Add canopies over 34 existing parking spaces and eliminate one parking space to provide secured bicycle storage.

Case Numbers	Action	Fees
SI-2020-01163	AA	
-		
-		
Meeting/Hearing Date:		Fee Total:
Staff Signature:	Date:	Project # PR-2020-004594

Re: Minor Amendment for the Huning Castle Apartments

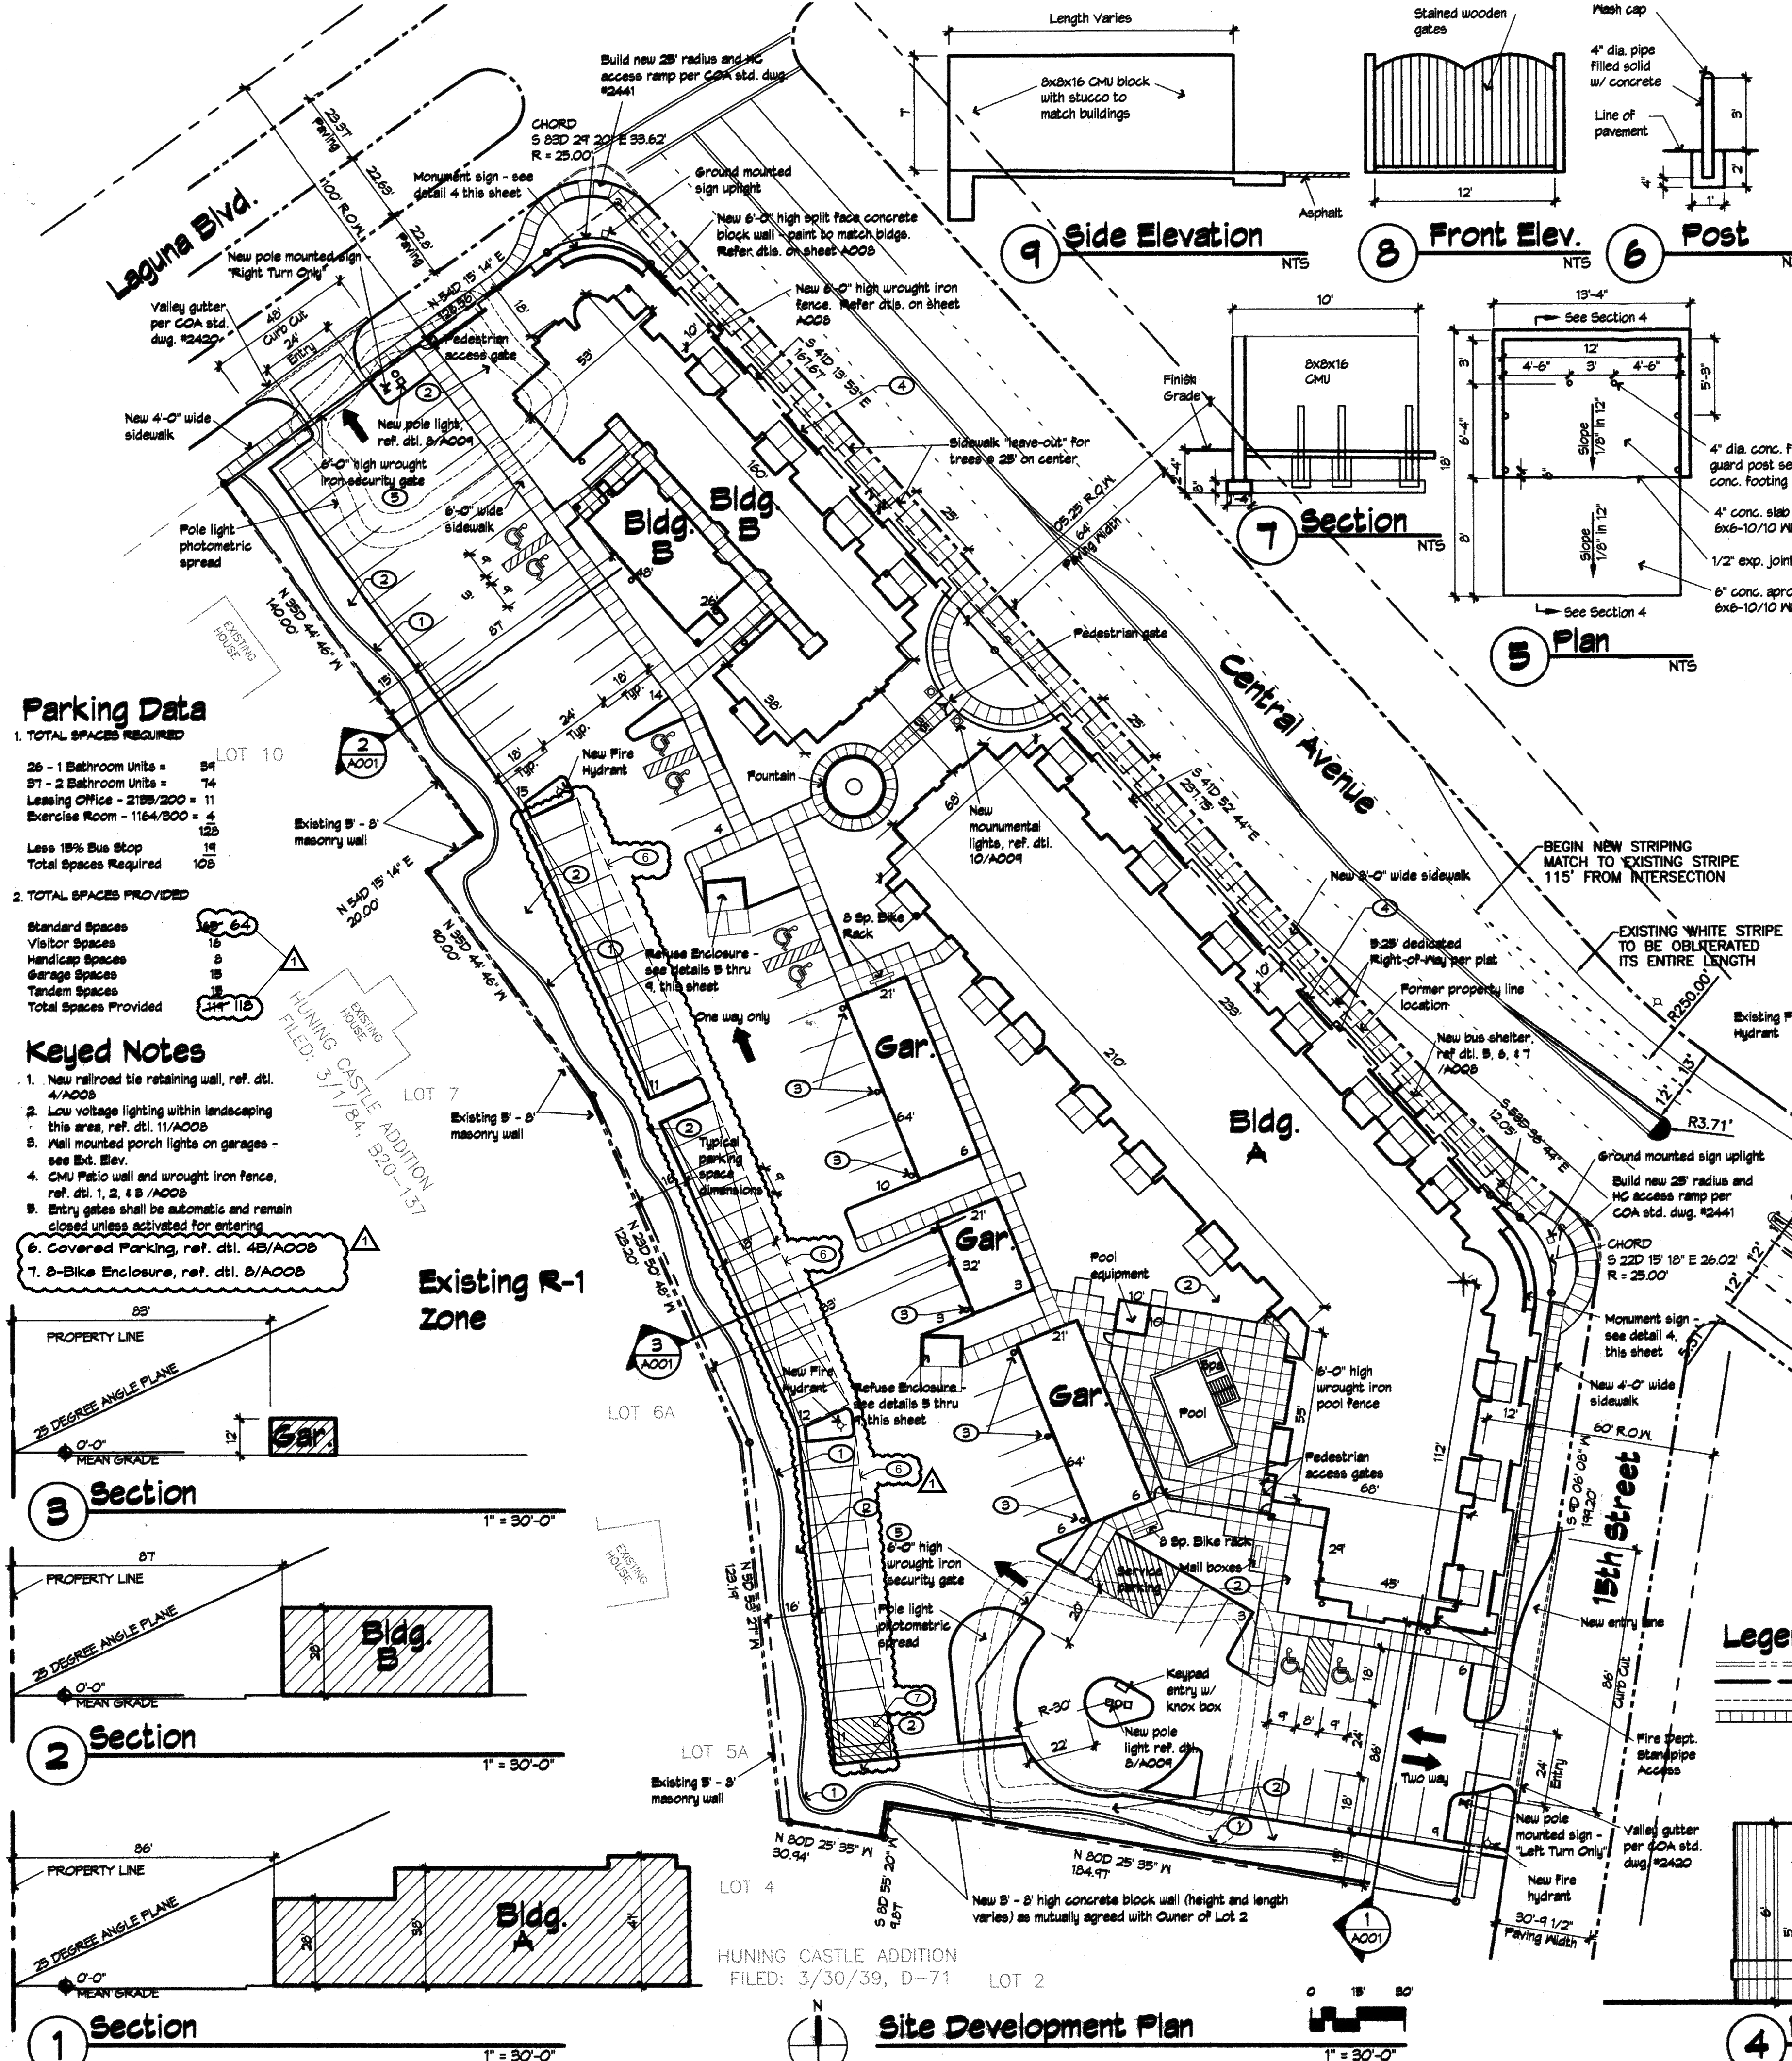
Hello again, Jim. I am just checking in with you regarding the subject AA. I never saw a response and just had the one comment.....

Jim, I had been reviewing the AA for this, and the only comment I had was that I could not find the "Bicycle enclosure" detail. Did I miss it somewhere?

proposed AA that was submitted. The Applicant does not have a design completed at this time. However, we are working with the Client to provide a general detail to describe the size and potential materials that may be further defined at a later stage as long as it is consistent with the general detail. Does this approach sound acceptable to you?

The purpose is additional secure bicycle storage beyond the required spaces, which already exist in racks on the site. We will share the updated sheets once we have them ready.
